**Consultation Response from KC,
Highways Development Management**

2026/91323 4, Wesley Place, Dewsbury, WF13 1HX

Demolition of existing building and erection of extension to existing motorcycle shop with additional parking

Responding Ref: 15-2NW/29

4.5 Visibility Splays

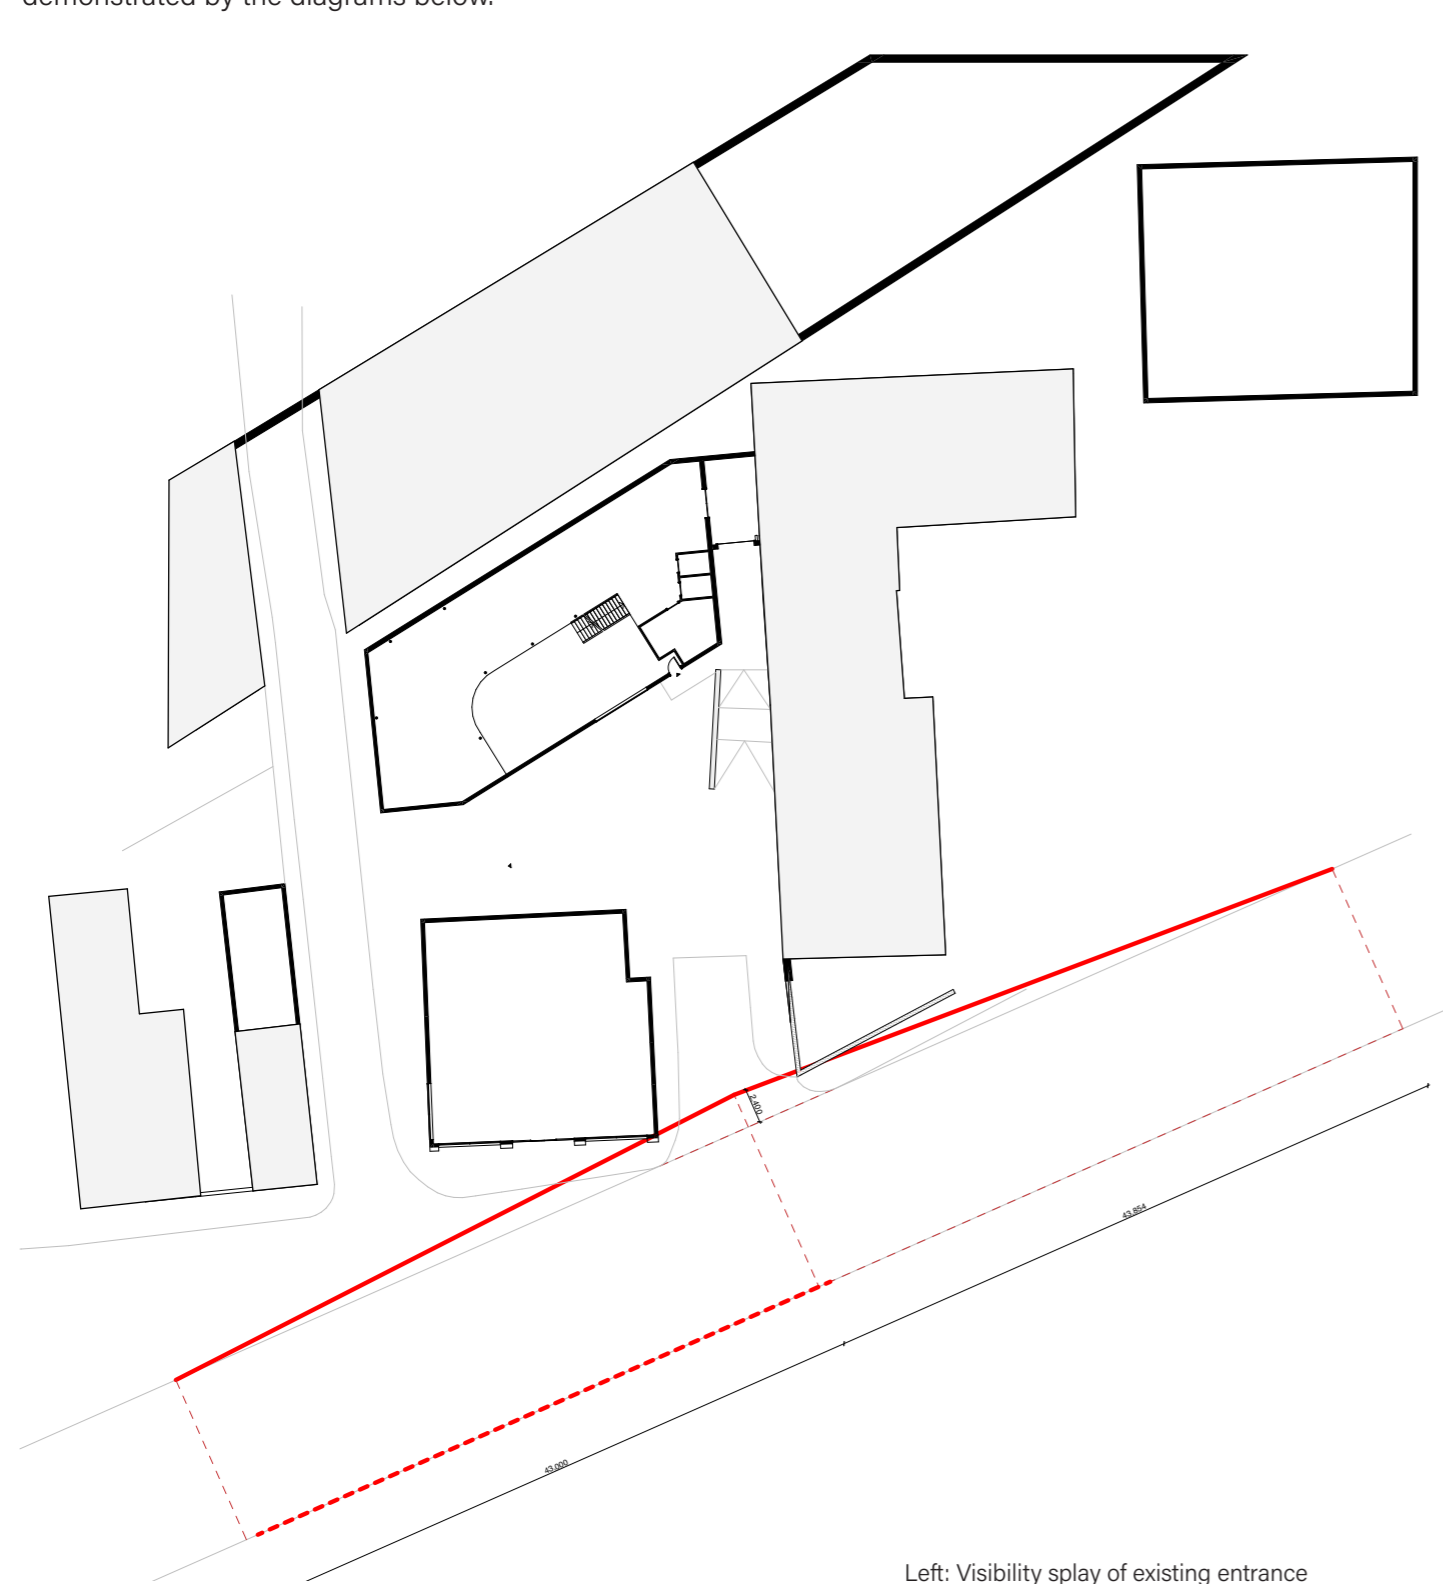
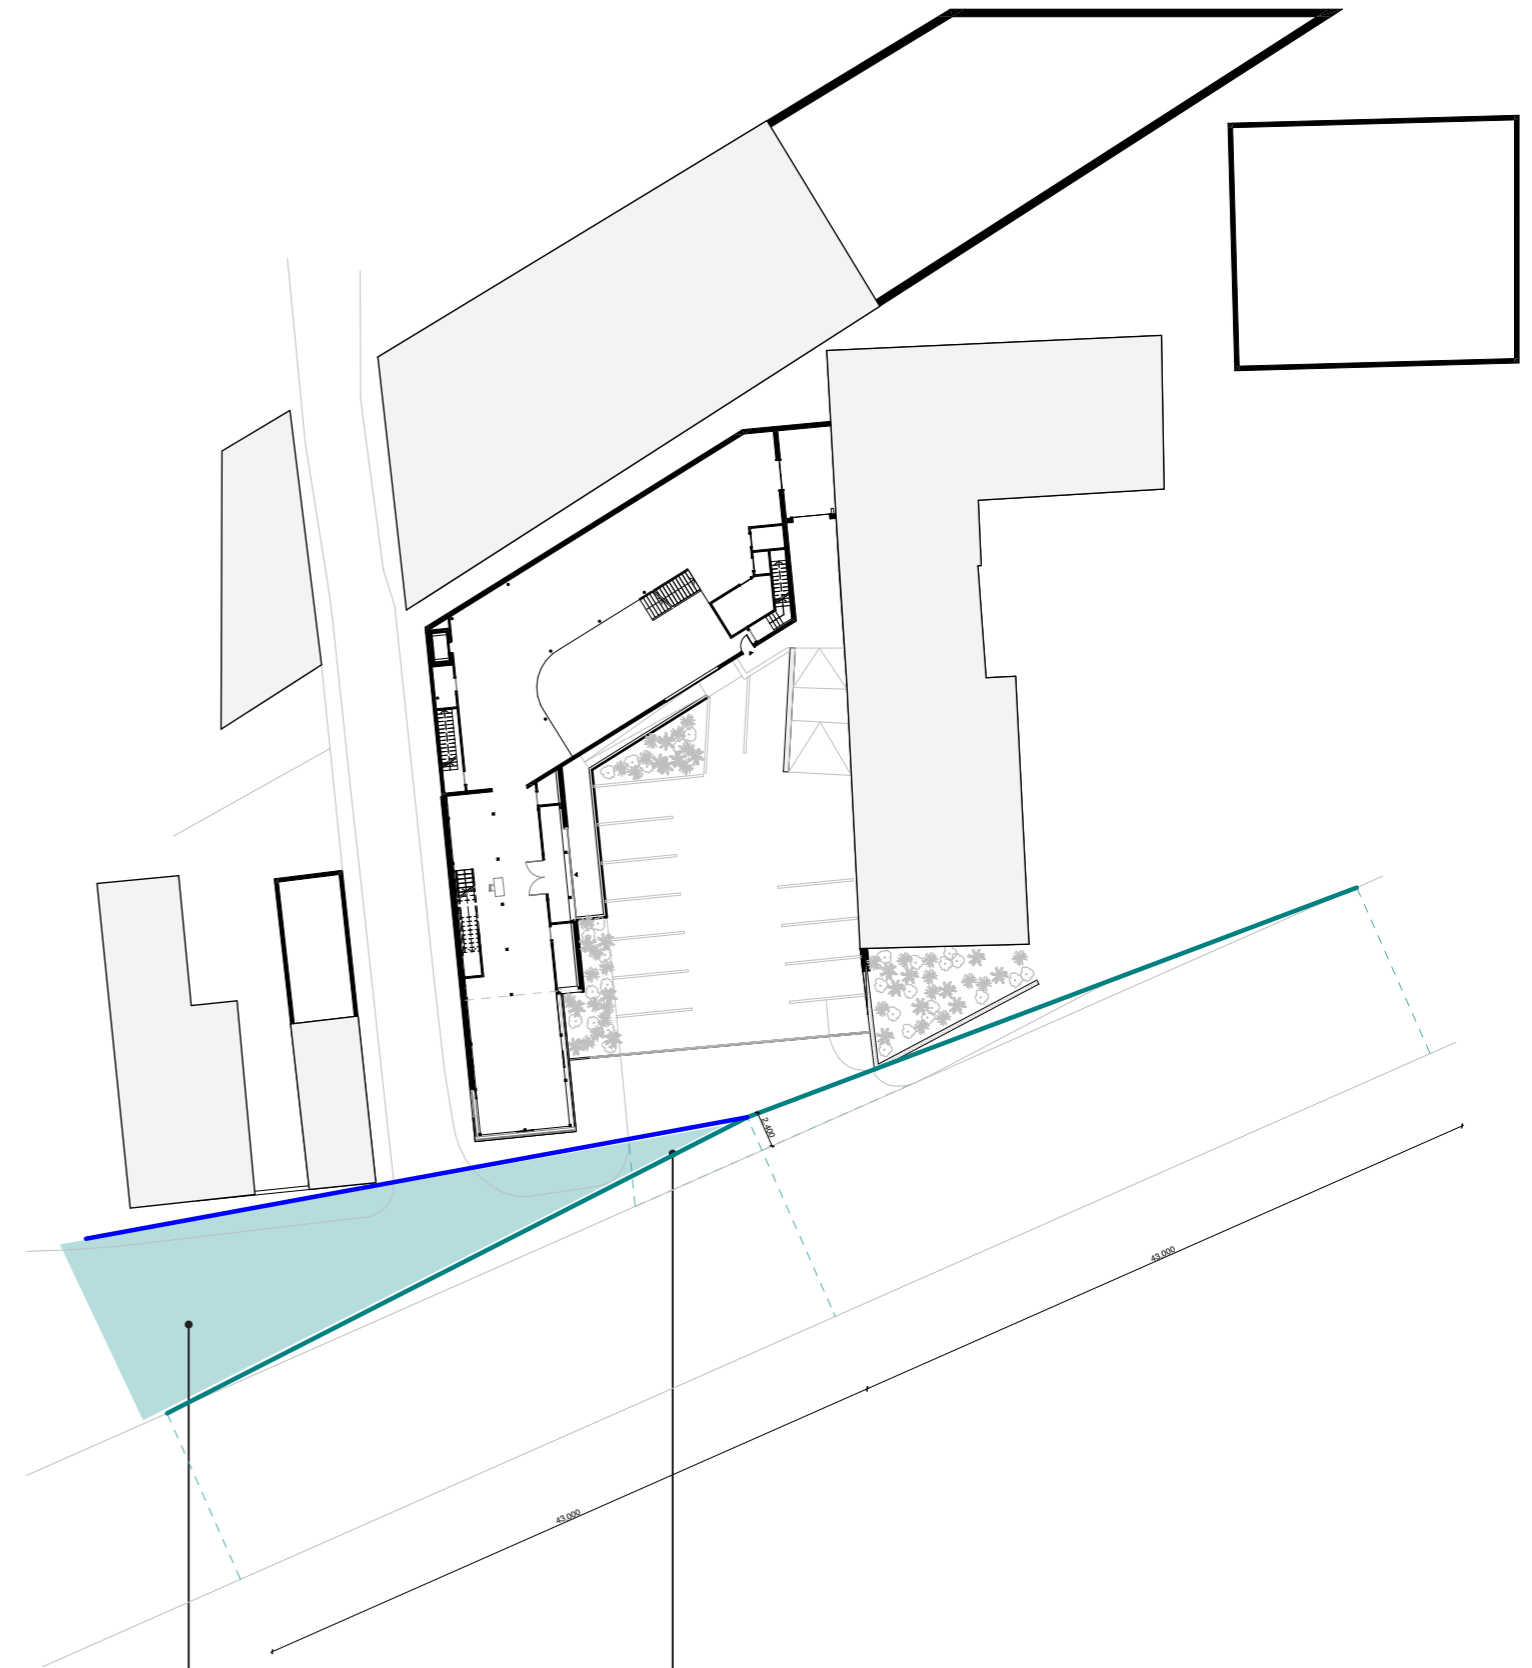
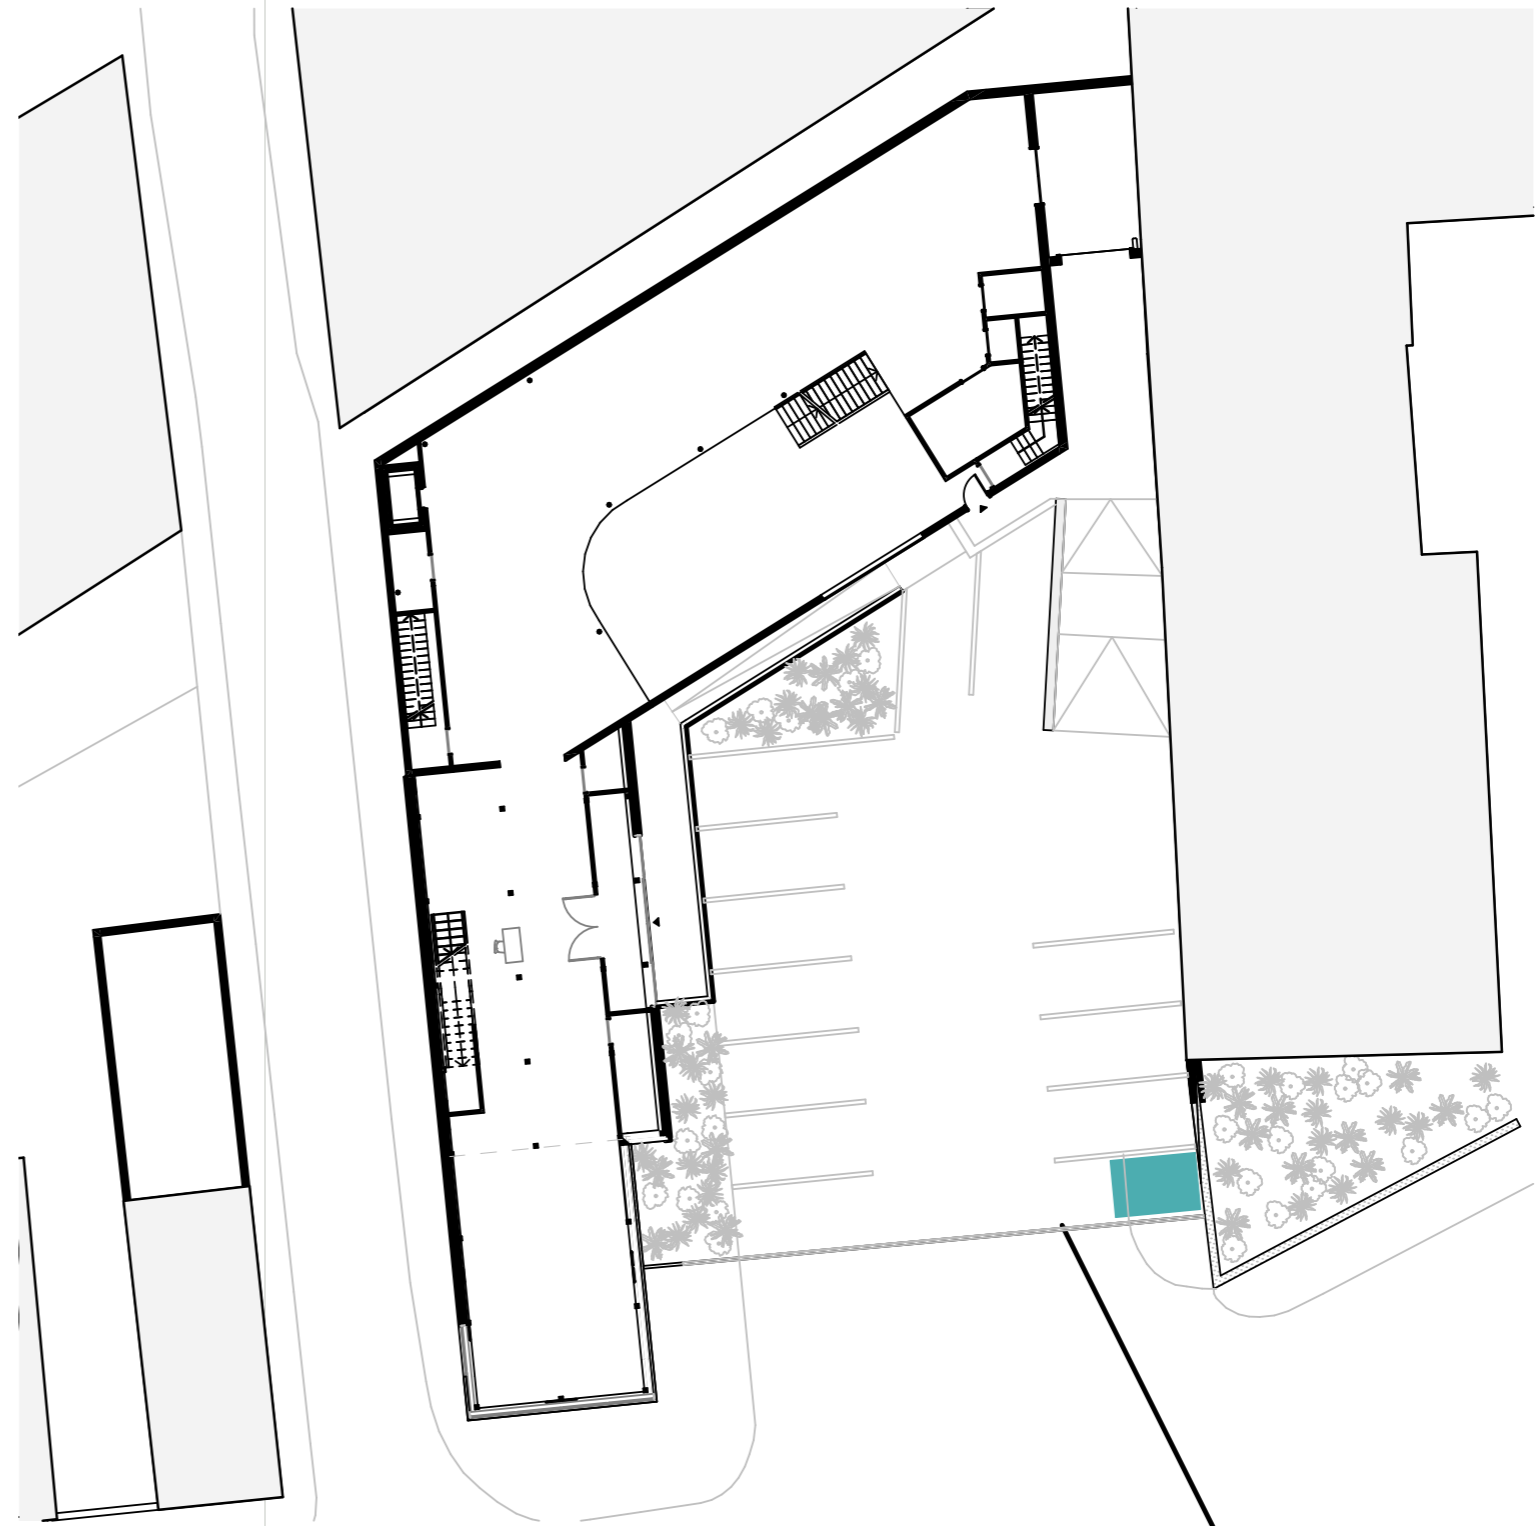
The existing gated and recessed access is to be retained from the A638 Dewsbury Ring Road. The demolition of the existing building at front and set back of the proposed new building would improve the visibility splay on approach from the south and right on exit to fully meet requirements of 2.4 x 43.0m in each direction. Additionally, the pedestrian approach to 4 Wesley Place to and from the south would be less constrained particularly at the pedestrian crossing point.
